Your ref: 3/2016/0695

Date: 9th August 2016

Planning Application 3/2016/0695: Lift existing stone flag floors to lay underfloor heating, formation of new opening from scullery of 'Friends Cottage' through to corridor of the lean-to extension at rear of 'Meeting Room' to link the dwellings and create one property. Removal of an existing pantry in the corner of the living room of 'Friends Cottage', Removal of the existing kitchen units and appliances in the existing lean-to extension to create new entrance hall. Opening up of wall between kitchen and dining room in 'Friends Cottage'; Meeting House, Sawley Road, Grindleton BB7 4RS

title
GENERAL ARRANGEMENT OF PROPOSED HEATING - ALTERNATIVE WITH UNDERFLOOR HEATING

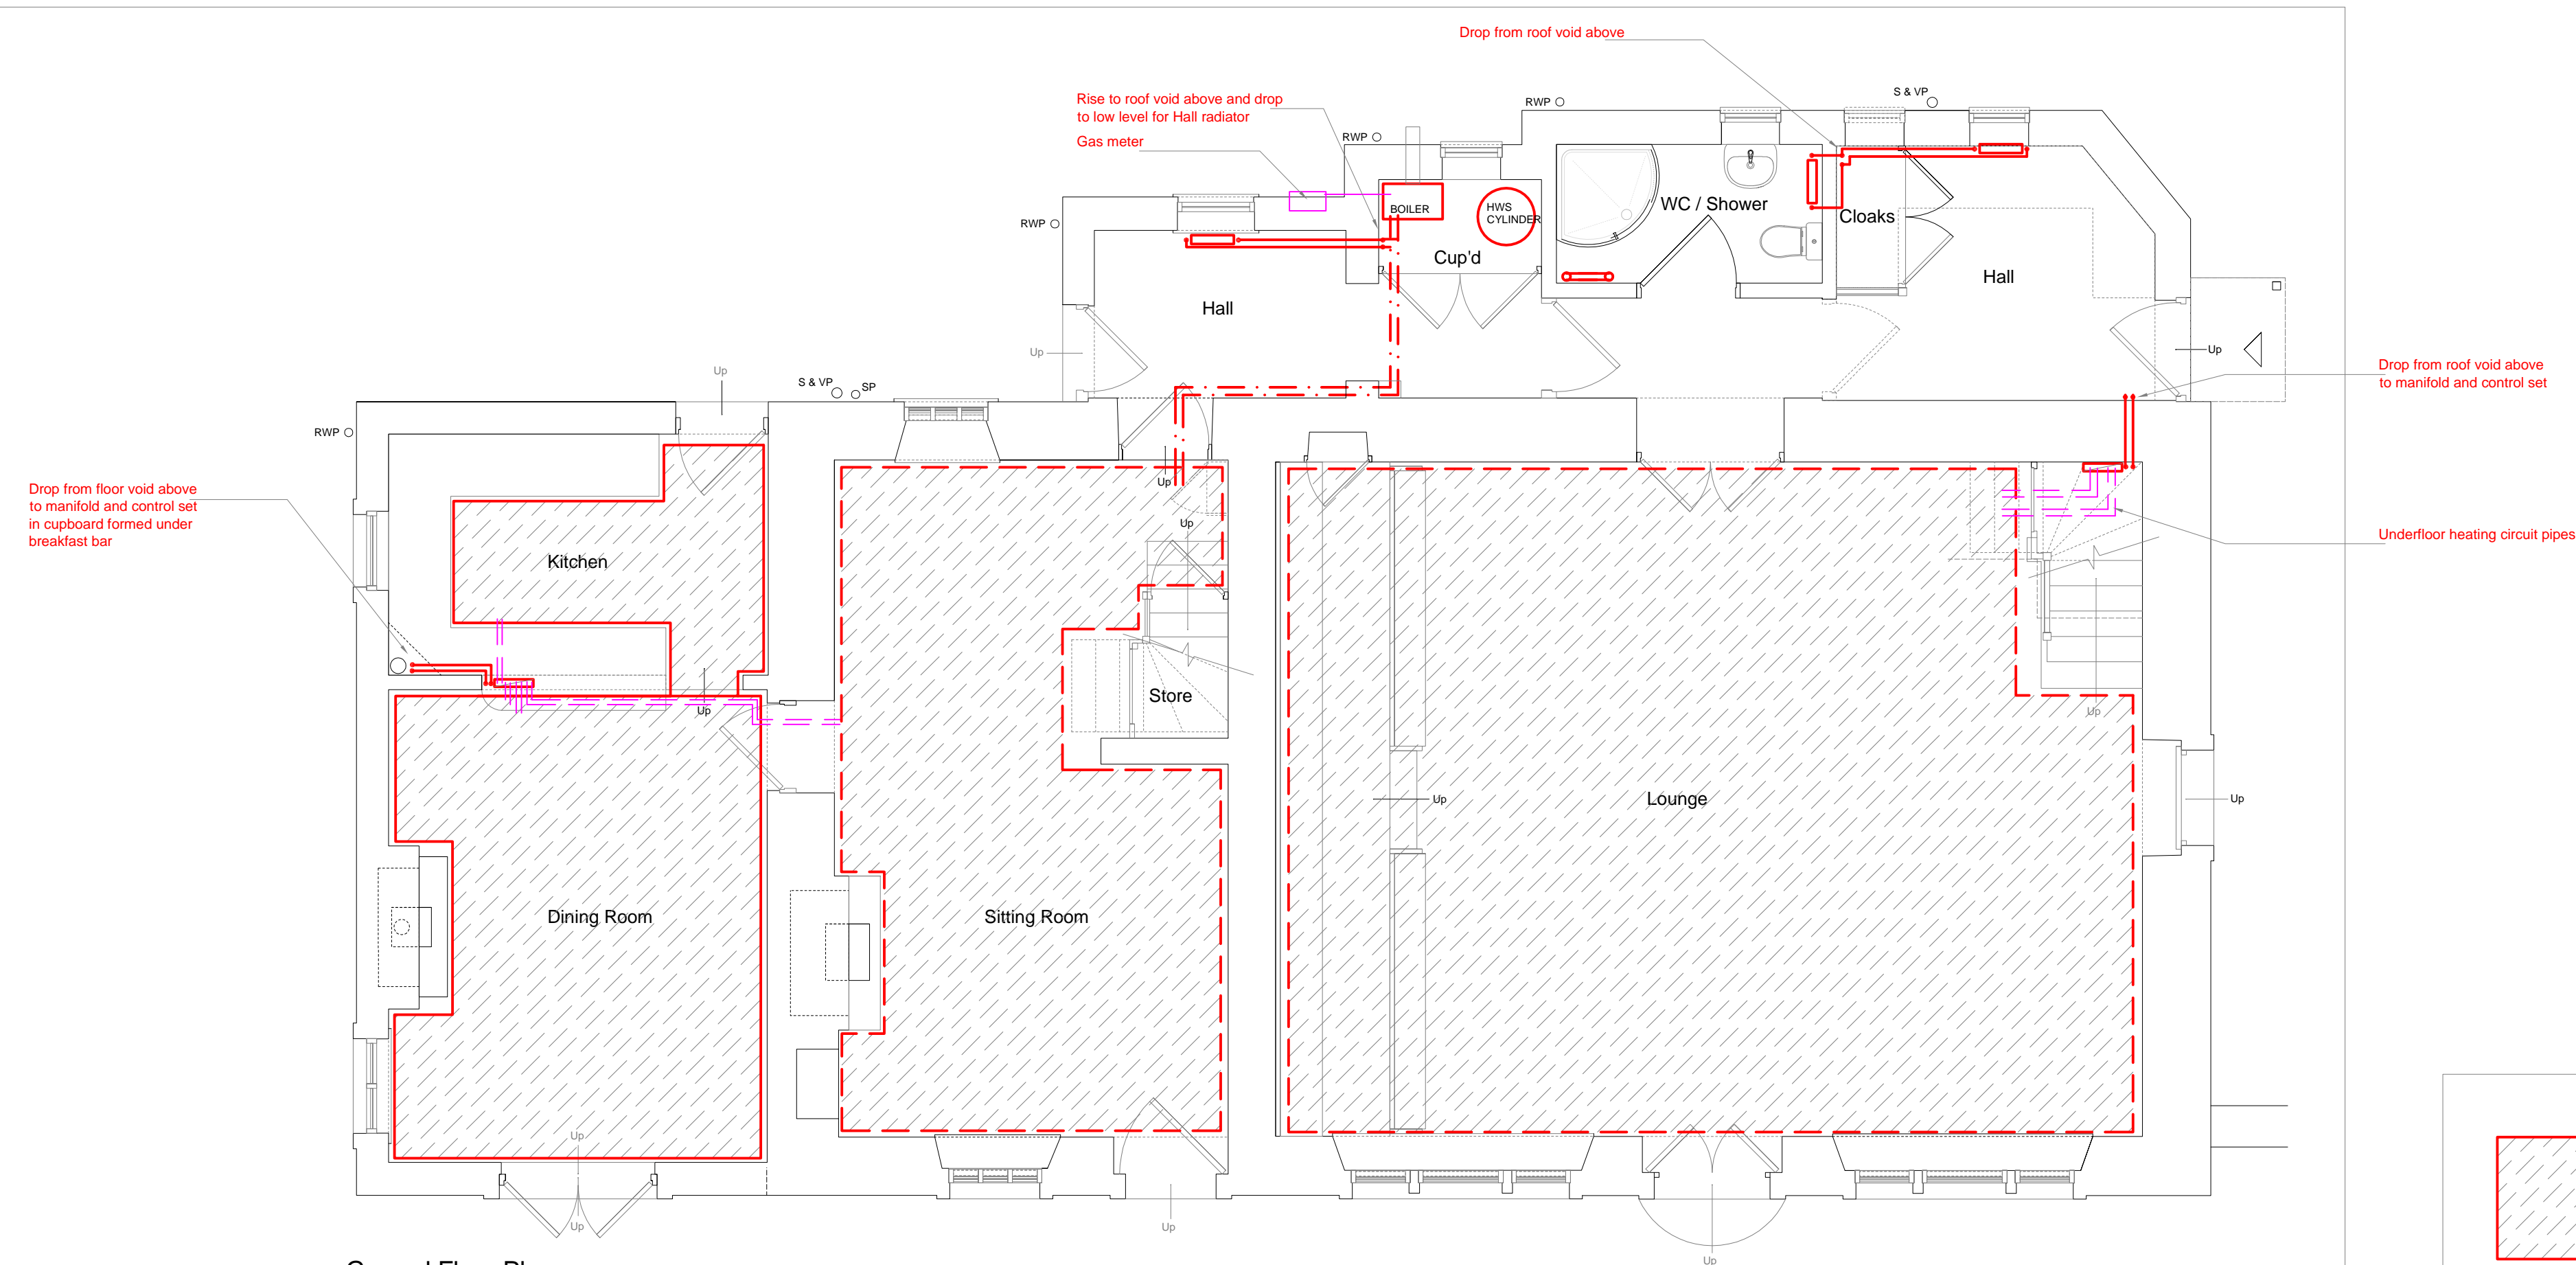
Secondly, the new heating system is shown on the plans to extend under the existing raised platform and pews. The DAS notes that "Existing joinery would be protected during the work" (p.3), but it is not clear how the platform and pews can be protected if it is necessary (as it appears) to remove them to allow this work to progress, nor what the impact of the new heating would be on the historic woodwork. The Heritage Statement says "*It is noted that there are no proposals to alter the fixed benches and panels on the west internal wall of the former meeting room, nor of the gallery on the eastern wall. The benches and gallery are important indicators of the original use of the building and are specifically mentioned in the listing*" (HS, p.7). It would seem sensible to require either (i) an assessment of the impact of the new heating on the historic woodwork along with a method statement setting out how the pews, platform and other joinery are to be protected, dismantled and reinstated as part of the works; or perhaps preferably (ii) that the underfloor heating scheme is amended so that it does not extend under the platform and pews.
